30 July 2018

Application: SSD 8703

Location: Tallagandra Lane, Sutton

Proposal: Solar Farm

Figure 7 Surrounding road network

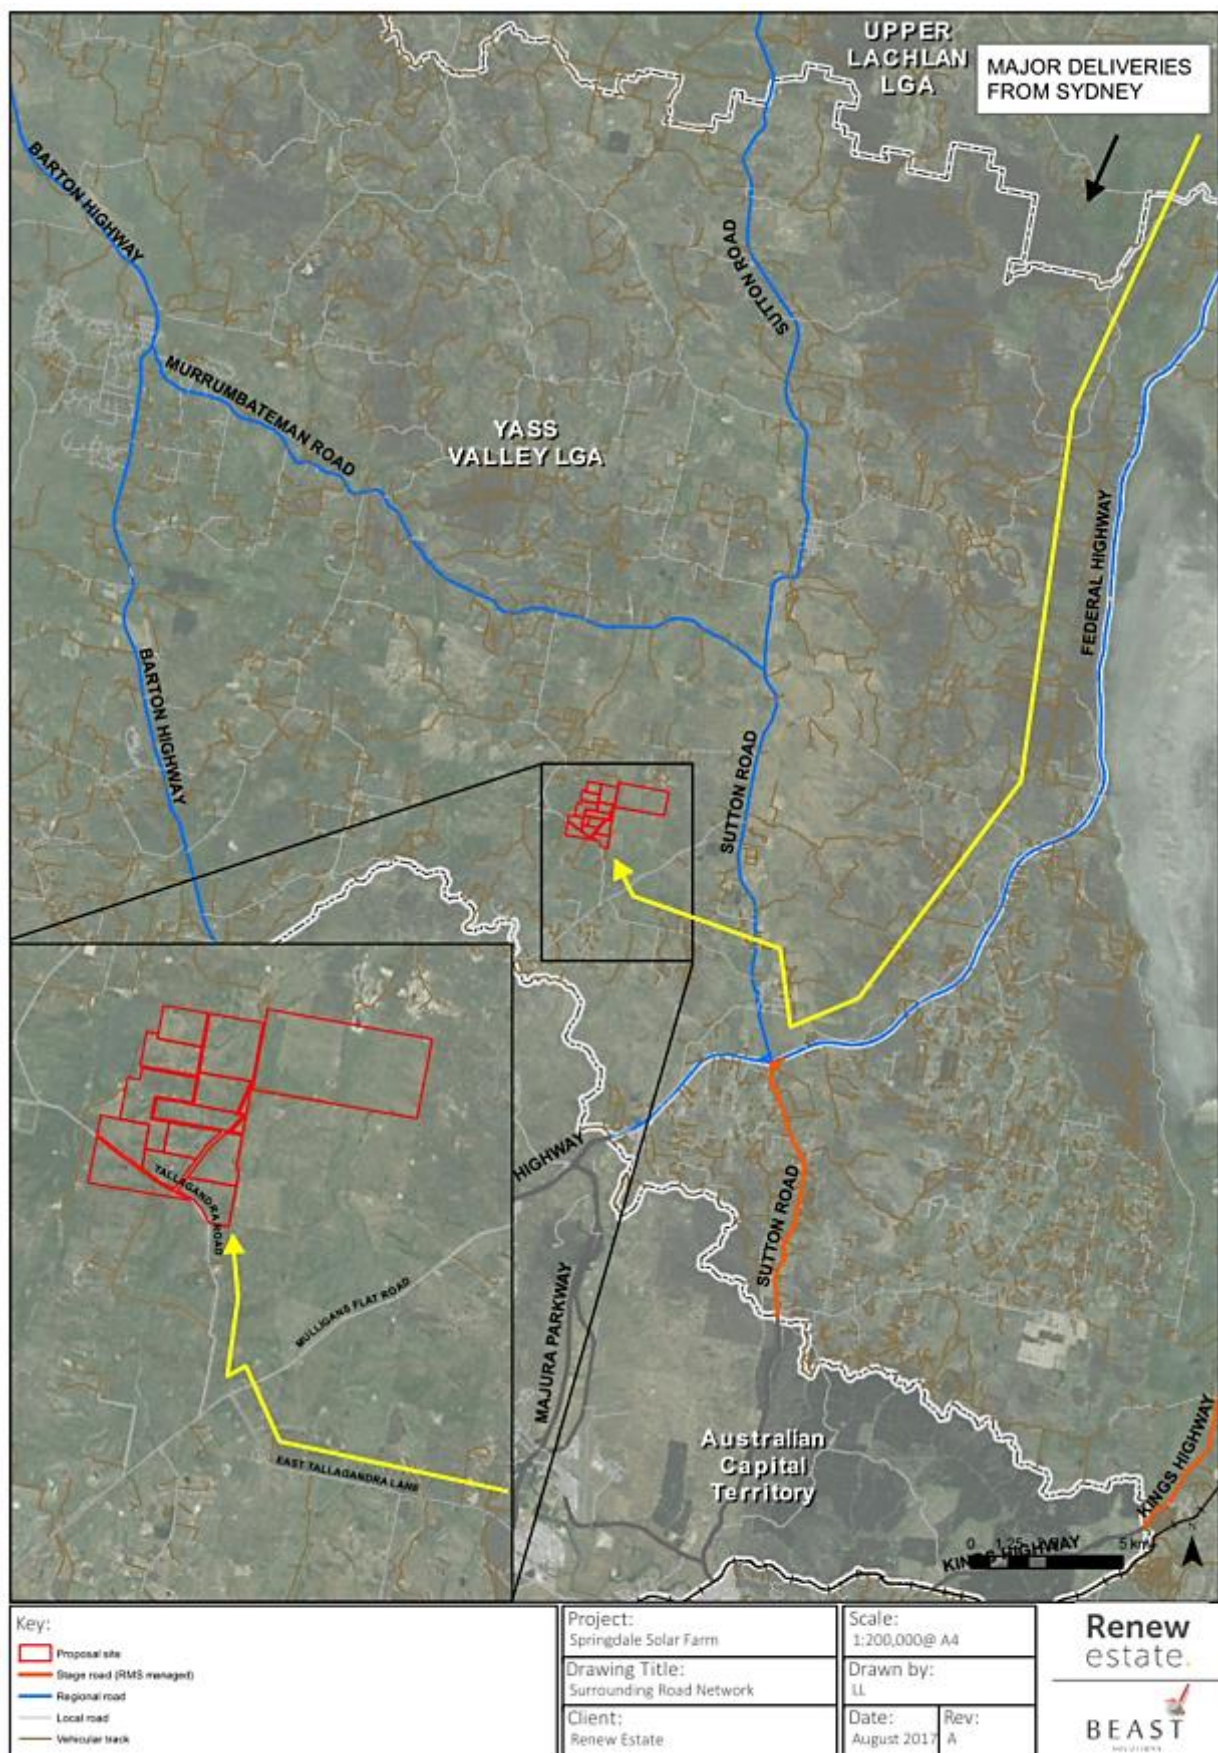
The proposed haulage route for heavy vehicles is:

- Sutton Road from the Federal Highway
- Through Sutton village to East Tallagandra Lane
- East Tallagandra Lane to Mulligans Flat Road
- Mulligans Flat Road to Tallagandra Lane
- Tallagandra Lane to the site entrances

The proponents are only proposing to monitor traffic conditions and repair any damage attributable to construction traffic. However the culvert crossing needs to be assessed for its adequacy for the increase in heavy vehicle traffic.

Heavy vehicle traffic through the Sutton village should be excluded during school hours to reduce conflicts with school traffic and children.
